Ribble Valley Borough Council  
Housing & Development Control

Application no: **3/2023/0865**

Address: **Land at Pewter House Farm Commons Lane Balderstone BB2 7LN**

Proposal: **Erection of one new self-build dwelling with associated residential curtilage.**

drawing number D 1174 / 23 /03
scale 1-500
issue date 27th july 2023
drawn Paul & Billy
SITE PLAN 1-500

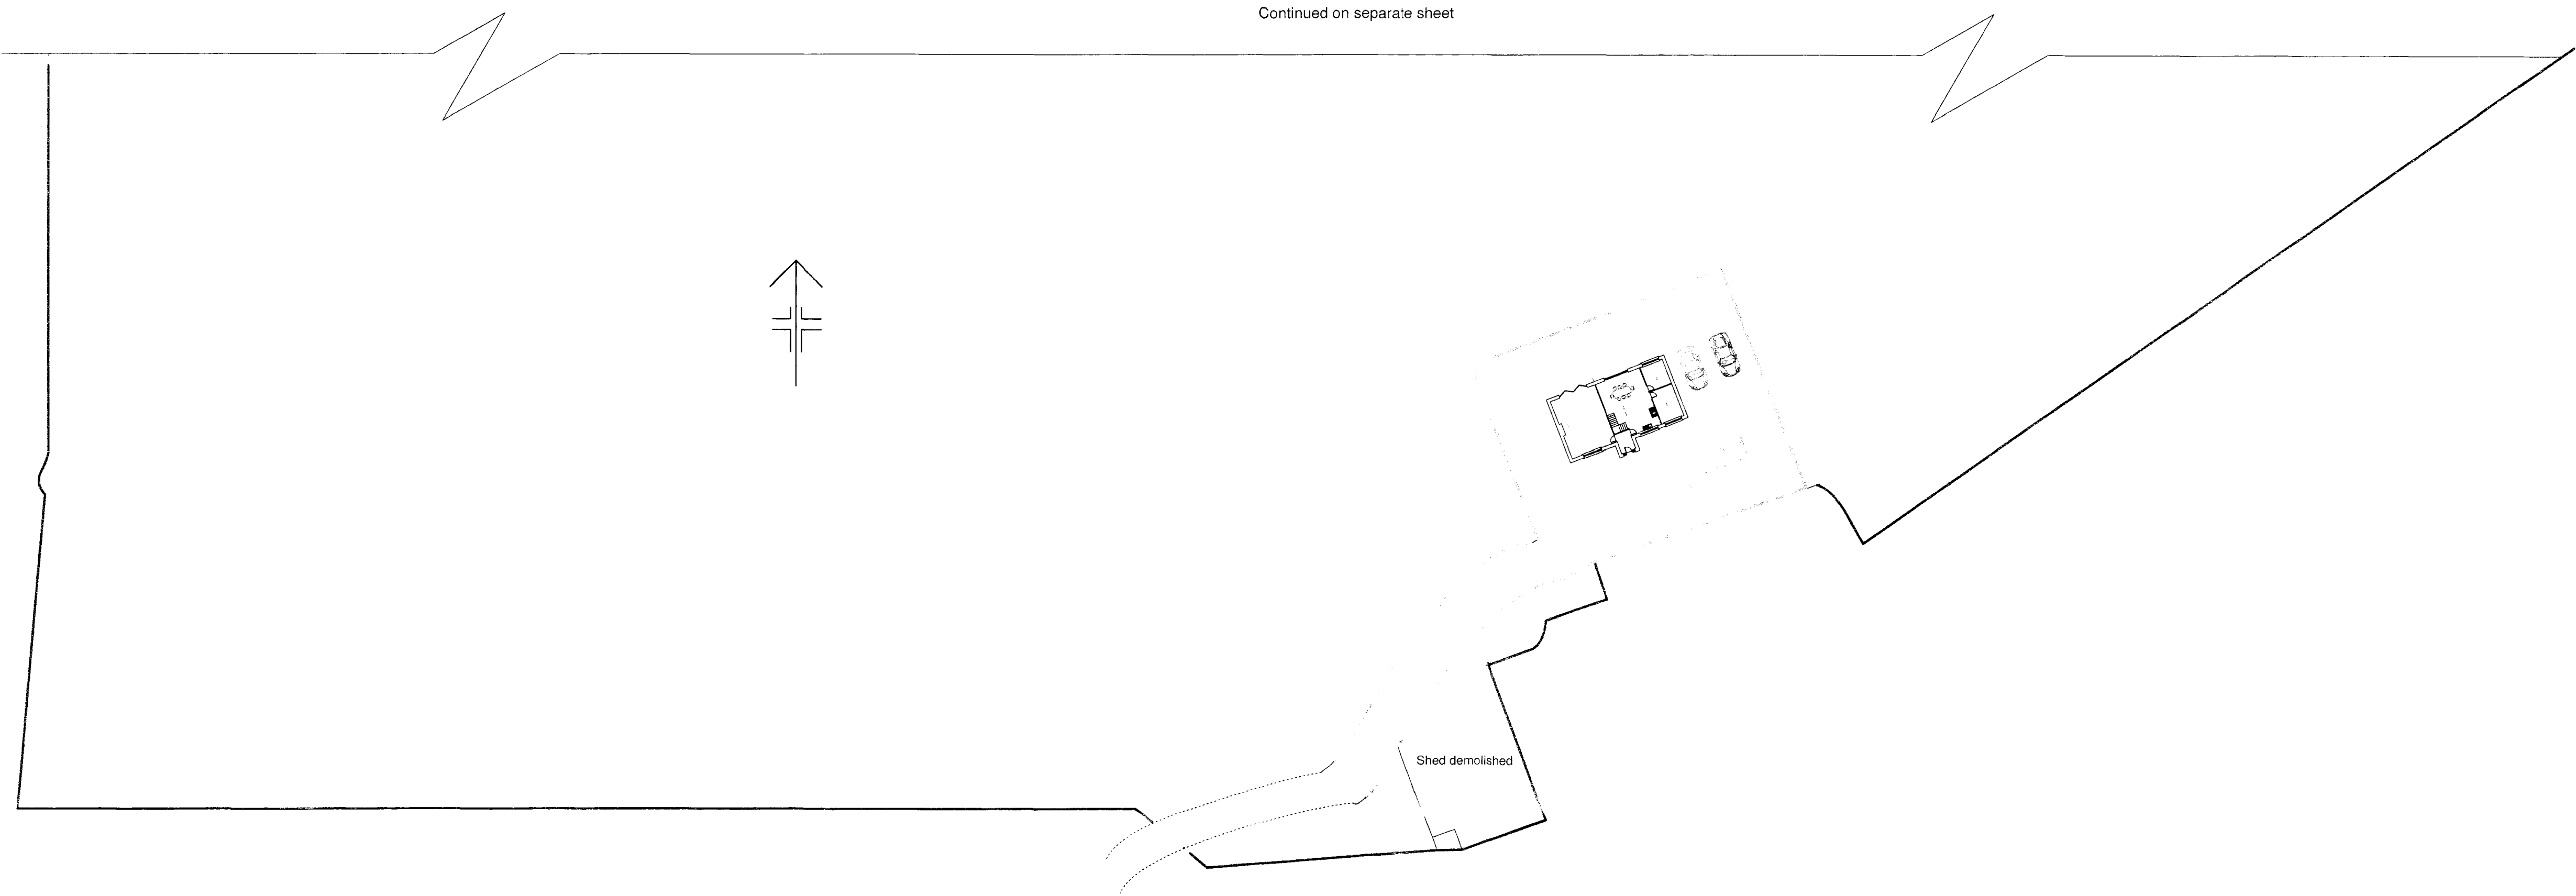
The LHA have reviewed the drawing number D1174/23/03 titled "Site Plan" and note that the proposed dwelling can provide 2 car parking spaces for the 2-bed dwelling. This complies with LHAs parking guidance as defined within the Joint Lancashire Structure Plan.
